WEST SUSSEX COUNTY COUNCIL CONSULTATION

TO:	Arun District Council FAO: Simon Davis
FROM:	Highways, WSCC
DATE:	03/01/2019
LOCATION:	Westergate House, Denmans Lane, Fontwell, Arundel, BN18 0SU
SUBJECT:	AL/123/18/PL Two storey extension to north east elevation to provide an additional 8 No. bedrooms.
DATE OF SITE VISIT:	N/A
RECOMMENDATION:	☒ Advice ☐ Objection ☐ Modification ☐ No Objection ☐ More Information ☐ Refusal
S106 CONTRIBUTION TOTAL:	£N/A

Drawing Title:
Proposed Site Layout

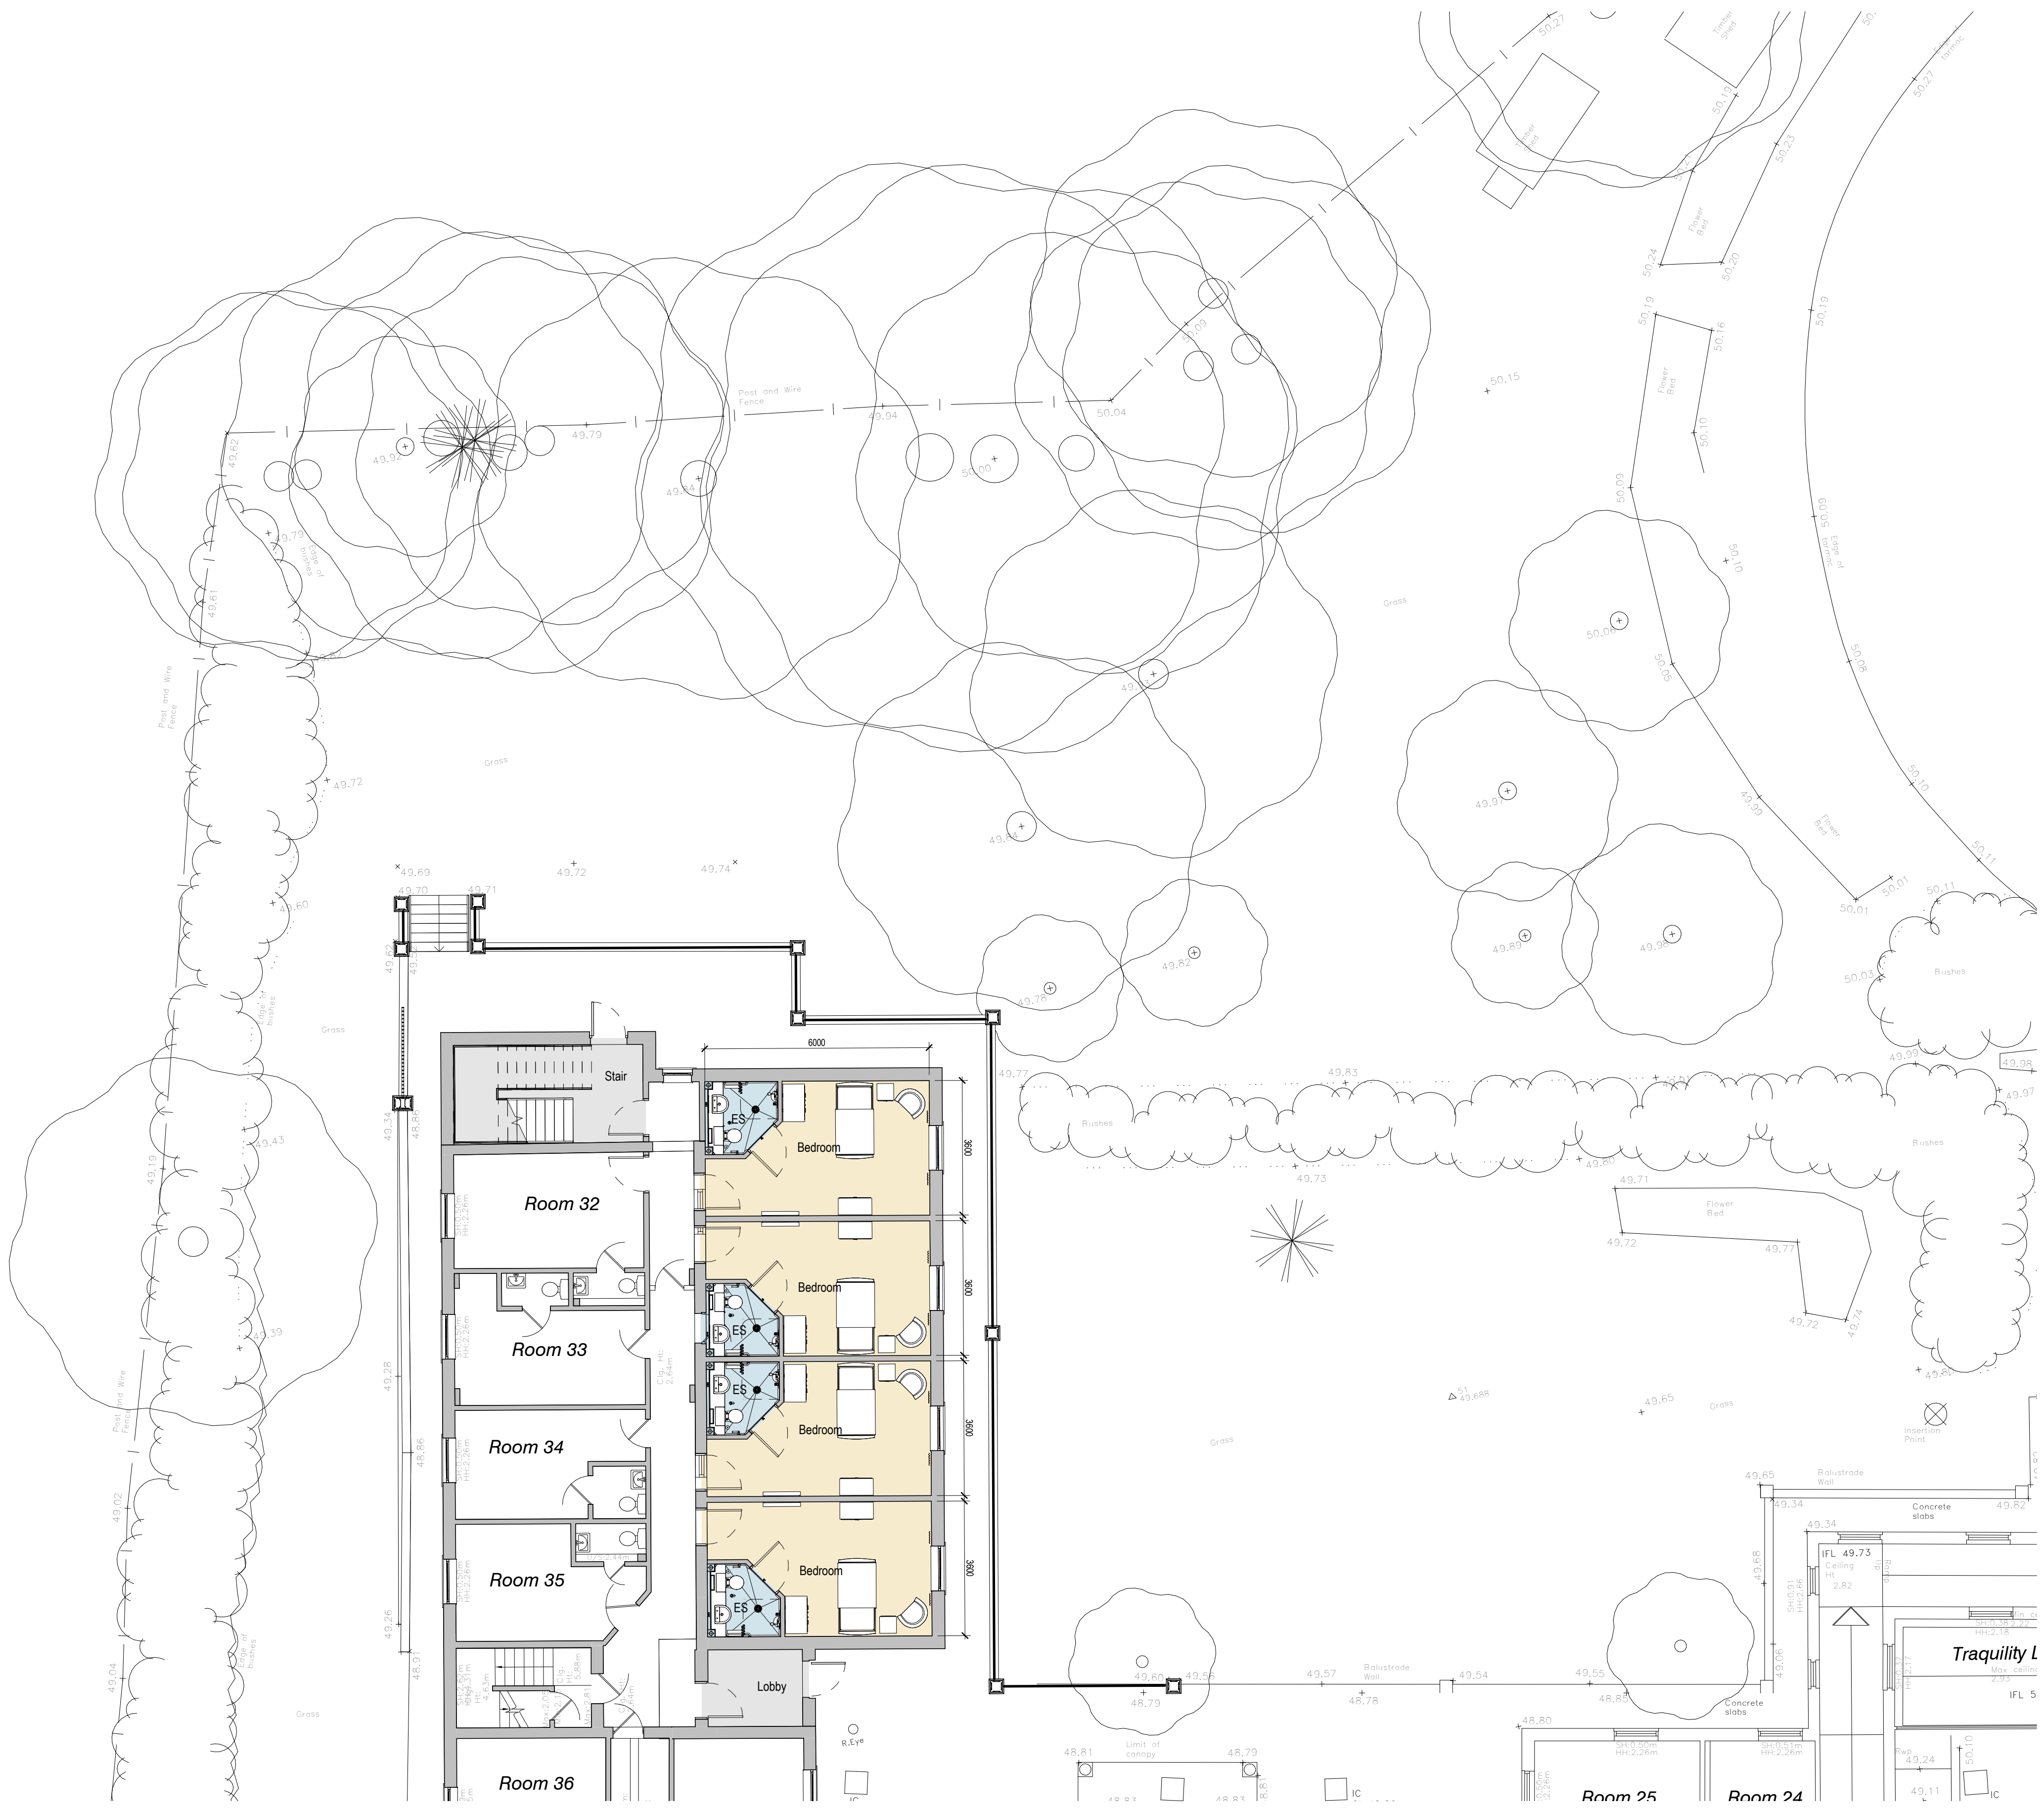
The site is accessed via two existing accesses onto Denmans Lane. It is unlikely that this small increase in resident numbers would result in a significant increase in daily vehicle movements or have an impact upon highway safety. An inspection of data supplied to WSCC by Sussex Police over a period of the past five years reveals that there have been no recorded injury accidents within the vicinity of the site. Therefore there is no evidence to suggest that the existing accesses are operating unsafely or that the addition of 8 bedrooms would exacerbate an existing safety concern.

The current available car parking provision would be adequate to allow both off-street staff and visitor car parking. There is also sufficient space on site for vehicles to turn and exit onto the public highway in a forward gear.
